Your Ref: OWPC20138
Our Ref: R/190/18/PL 31-07-2018
Please ask for:
Mrs A Gardner

Demolition of 1 No. existing house & grounds & erection of 2 No. new detached dwellings. This application may affect the character & appearance of the Station Road, East Preston Conservation Area.

St Marys Close Hurst Road Rustington

Thank you for your internet representation made on 10th October 2018 which has been recorded as '**an objection**' with the comments as follows:

Drawing Title:
ADDITIONAL DWELLINGS
BLOCK/ SITE PLAN

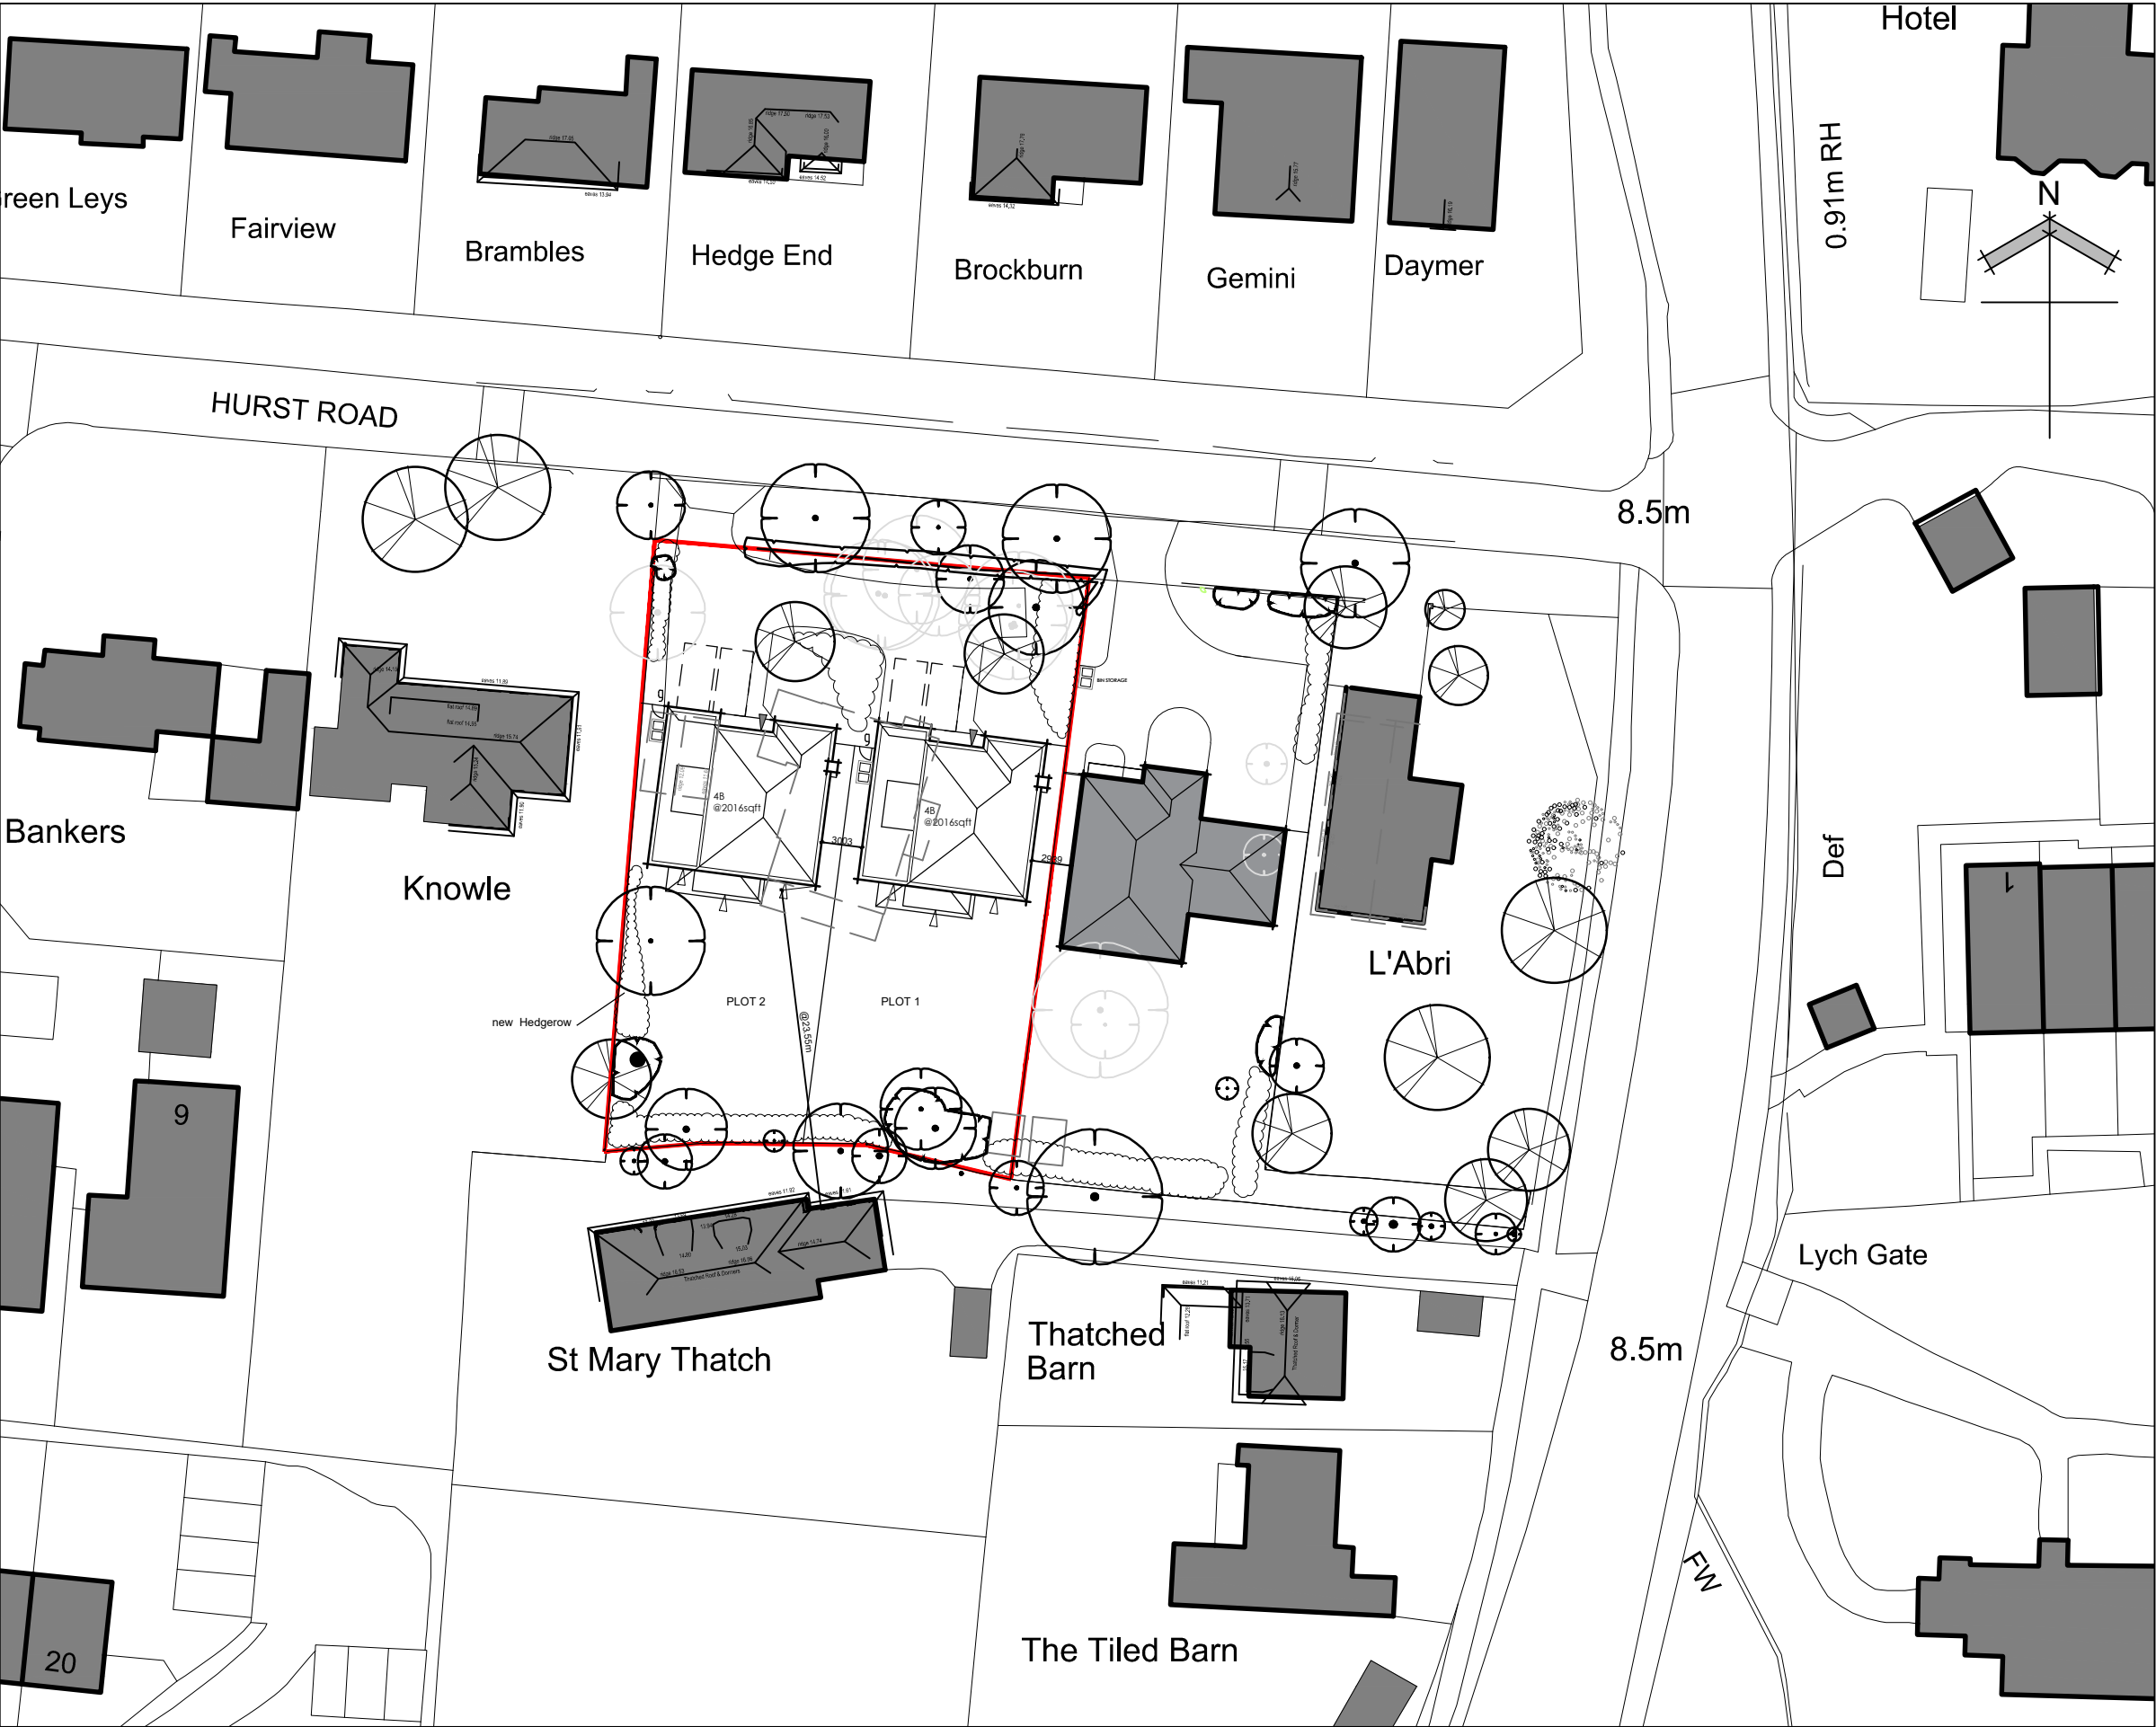
The fact that these two properties have a shared drive could cause problems and arguments later, with the result that cars could be parked on Hurst Road.

- 1. That these 2 properties are identical unlike the rest of the road.*
- 2. That these 2 properties share one driveway as apposed to the properties in the rest of the road, which have their own drive.*
